DEVELOPMENT REVIEW BOARD
SUPPLEMENTAL SUBMITTAL

PROJECT NO. 2020-003461 (17EPC-40043)
Application No. SI-2020-00052

SUBMITTAL DESCRIPTION: Revised plans, Approved Fire One, and response to comments

RE: Project #2020-003461/SI-2020-00052 (17EPC-40043), Taylor Ranch Housing
Site Plan-EPC Major Amendment

ENGINEER'S SEAL RONALD R. BOHANNAN NEW MEXICO 7868 PROFESSIONAL ENGINEER 7/28/2020 RONALD R. BOHANNAN P.E. #7868	SARANAM AT 4701 MONTANO RD NW SITE PLAN	DRAWN BY BF DATE 7/28/2020 2019080_SPE SHEET # C1 JOB # 2019080
---	---	--

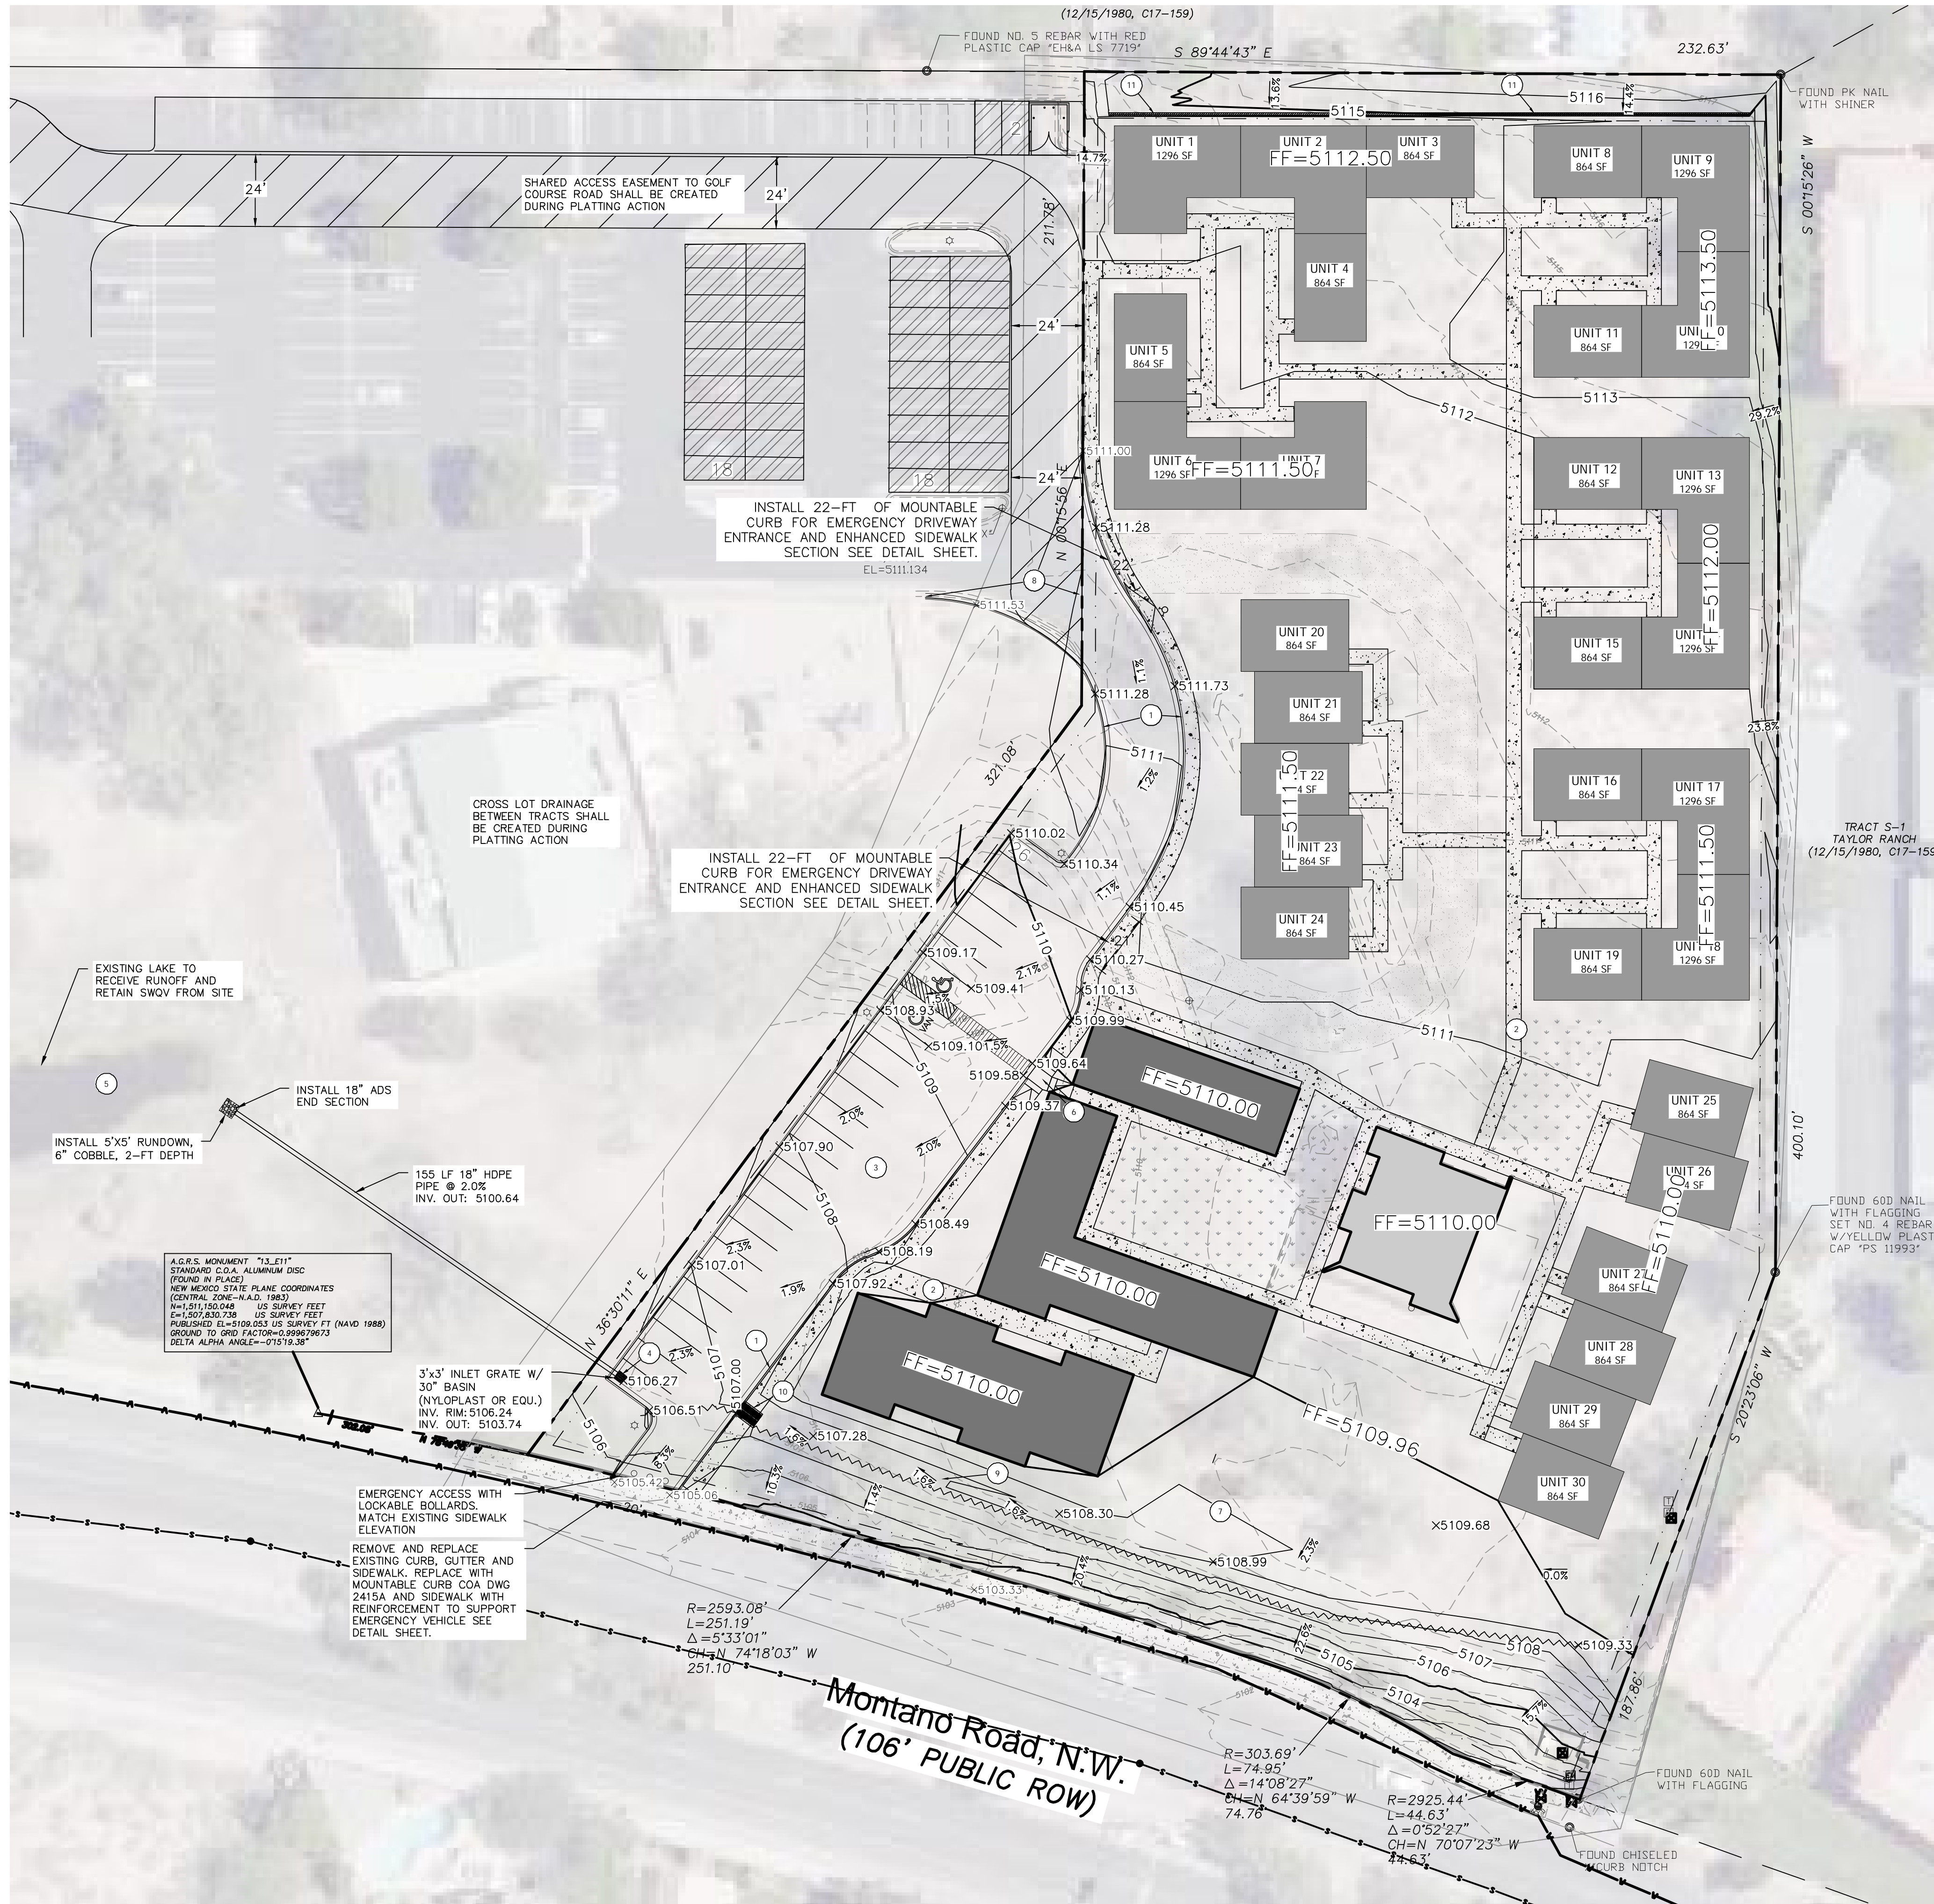
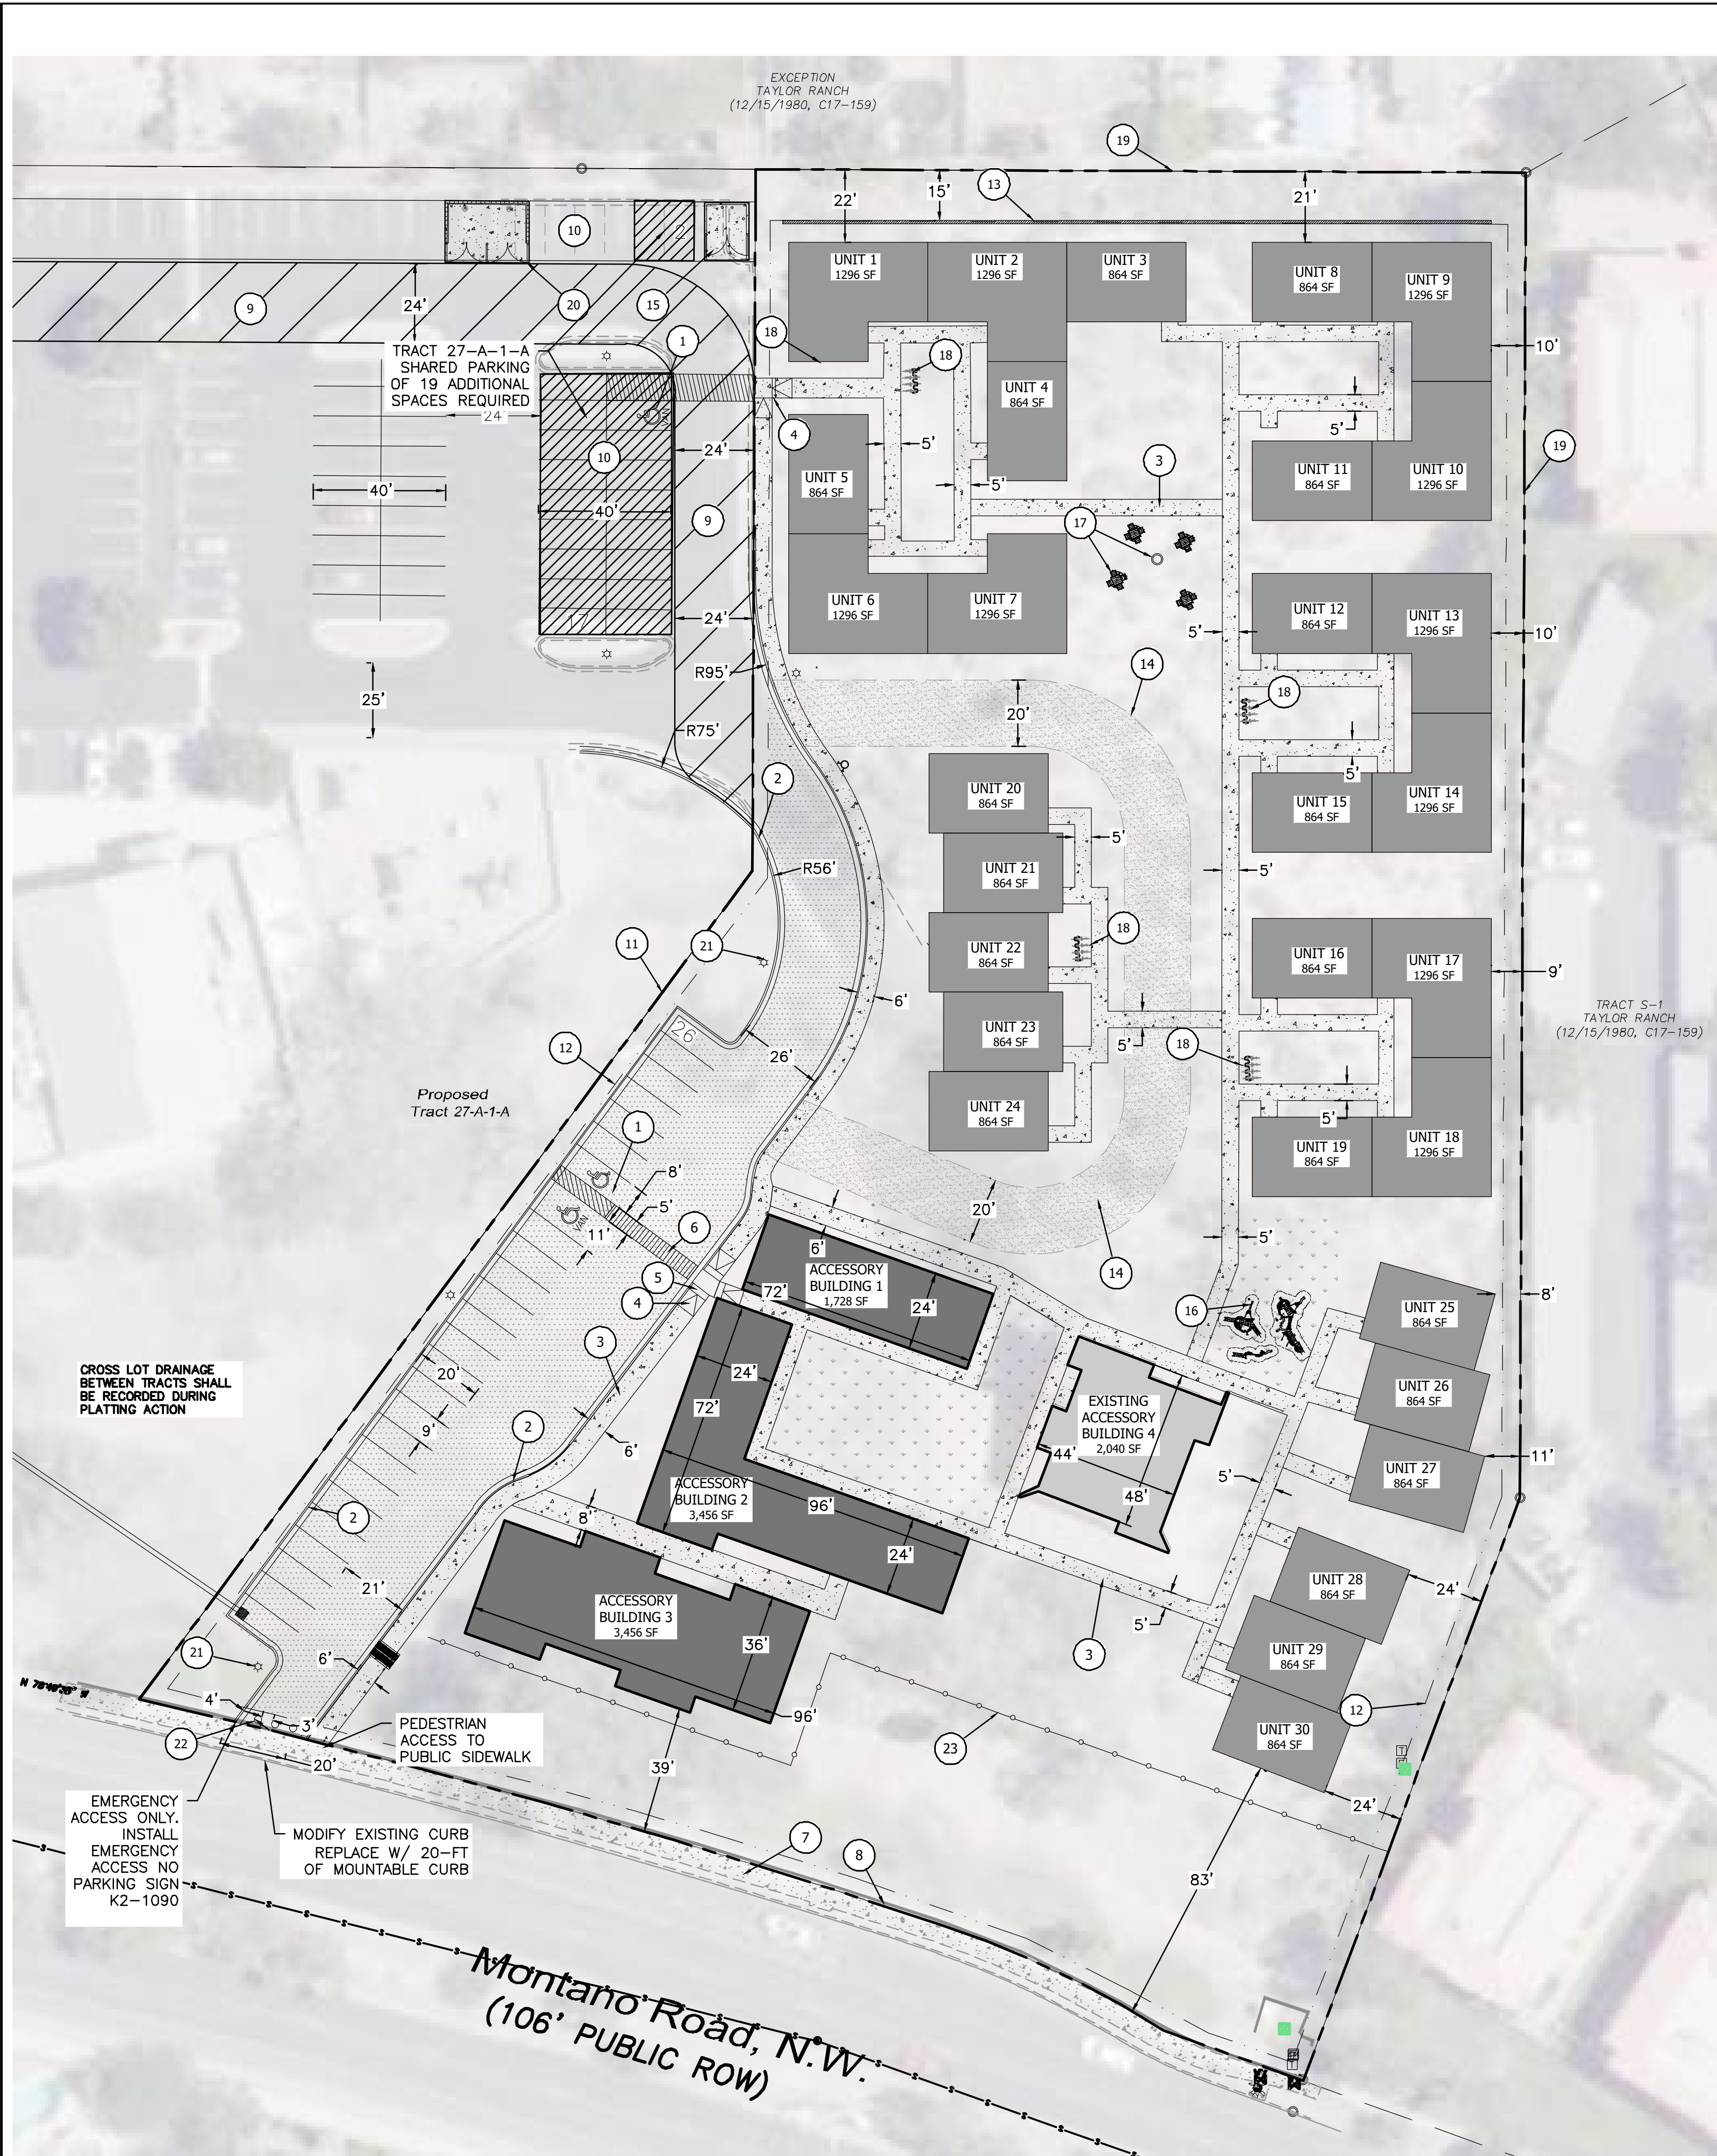
3. Both entrances to the site were listed as emergency access. Where is the site access that is non-emergency?

4. For anything that is emergency access, signage shall be provided at the access off of the public right-of-way.

6. Call out all walkway widths. However, for an MX zone, follow IDO requirements for sizing of walkways based upon square footage of buildings, particularly the accessory buildings.

8. Label Tract 27-A-1-A for shared parking. Shared parking can be established on the plat. What is required parking for Tract 27-A-1-A so that it can be established that all parking requirements are sufficient.

1. Condition 3B- correction: It appears that 16 spaces are provided, though the main site plan says 12 spaces.

1. A fence was added to the main site plan (Sheet C-1) near the southern portion of the subject site (keyed note 23).
2. A detail of the unauthorized fence was added to Sheet C-4.
3. The height of the new wall on the subject site's northern side was changed from 2 to 3 feet.
4. The crosswalk detail was removed from Sheet C-4 and must be re-instated and comply with IDO 14-16-5-3-(D)(3)(c).
It was relocated, still on C-4 to the right side of the page.
5. The second sheet of the landscaping plan was removed and needs to be put back.
6. Building perspective Sheet B-1 was added, and should be removed, since the EPC didn't see or approve it and it was not a condition.
7. The northern landscape boundary was changed to a monoculture of Bosnian Pine, which is not what the EPC approved and was not in a condition.
- 8.

Response: There is one non-emergency access is from Taylor Ranch Rd. utilizing the existing Church driveway access and parking lot drive isle as the thoroughfare to the property. This is protected with a cross-access easement.

The emergency access is from Montano Rd. with a second access from Taylor Ranch Rd. .

Response: An emergency access no parking sign was added to the site plan C-1. The Fire Marshall will inspect the property prior to occupancy and any additional requirements shall be installed as necessary to meet IFC requirements.

Response: added sidewalk widths between buildings, they are predominately 5-ft in width, and the main pedestrian connection is 6-ft in width.

Response: Note added to C-1 to label the 19 additional parking spaces covered under the shared parking.

Response: Site Plan updated and details 16 spaces provided (C1).
